Drg No.: SBS/784/06A

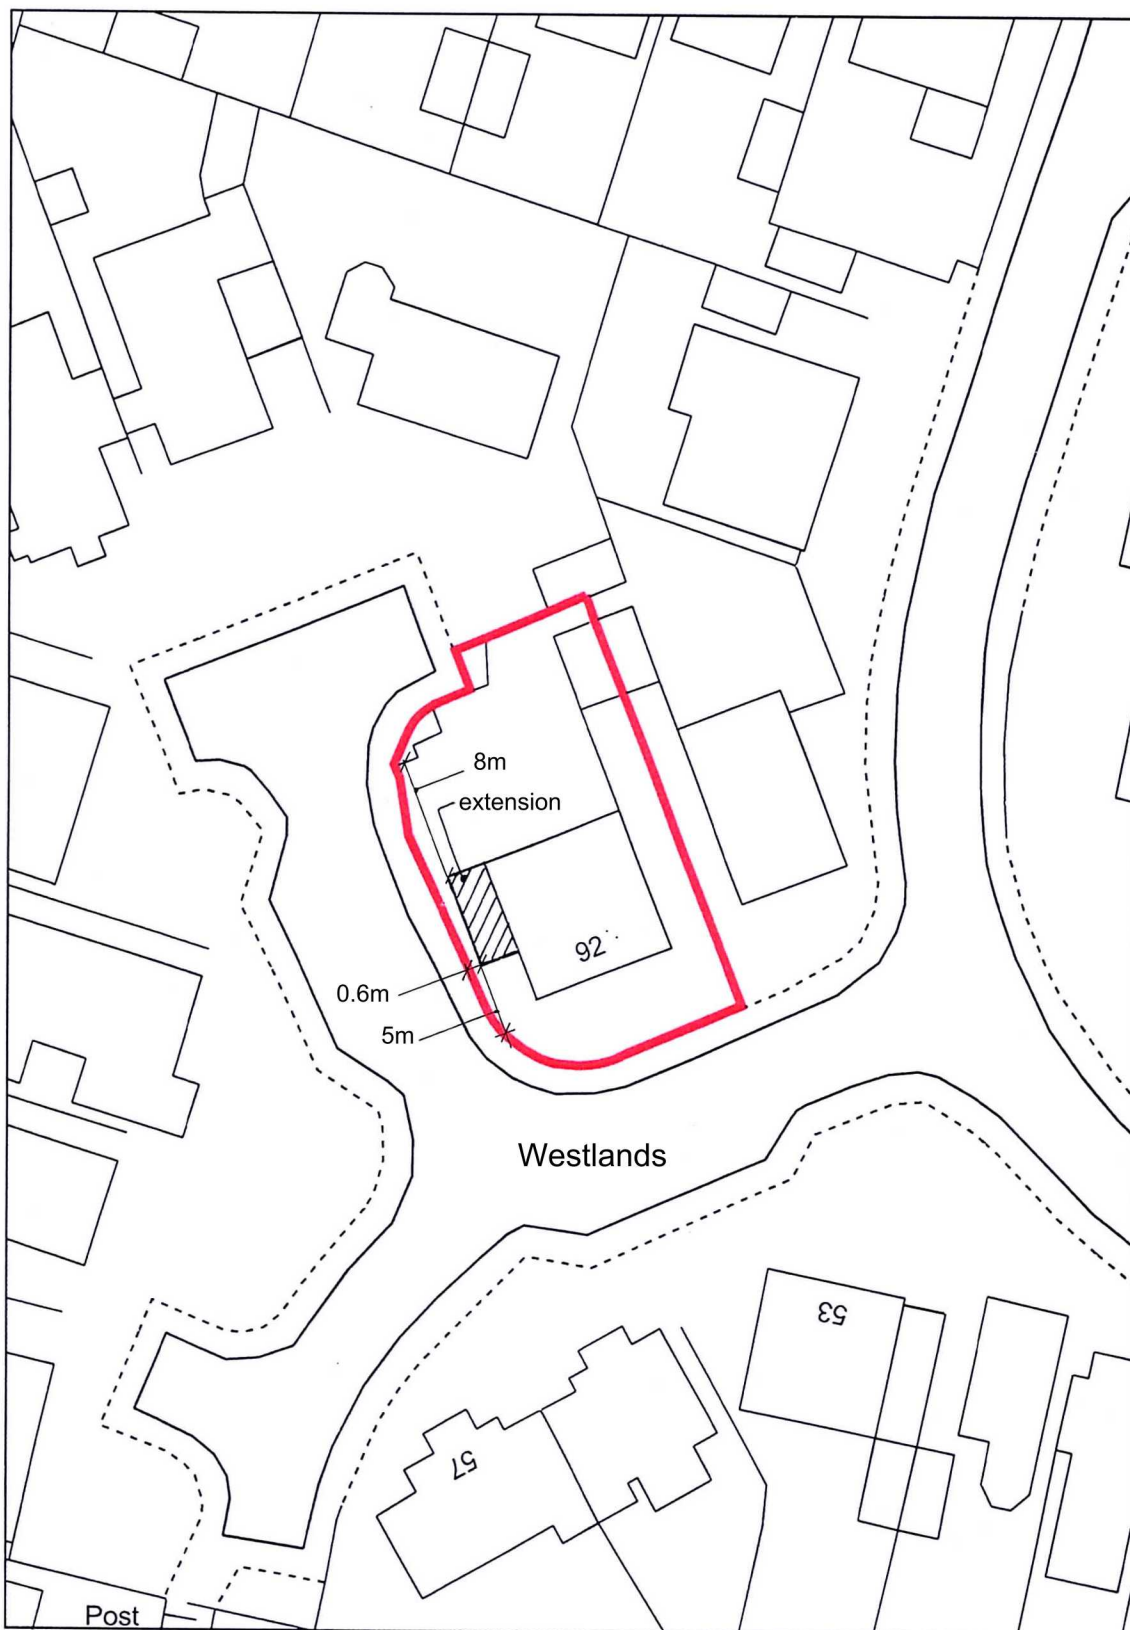
An invalid letter was sent 23/2 requesting for dimensions to be added on the block plan from the proposed extension to all site boundaries.

I attach revision A of the Block plan with distances to boundaries shown, as requested.
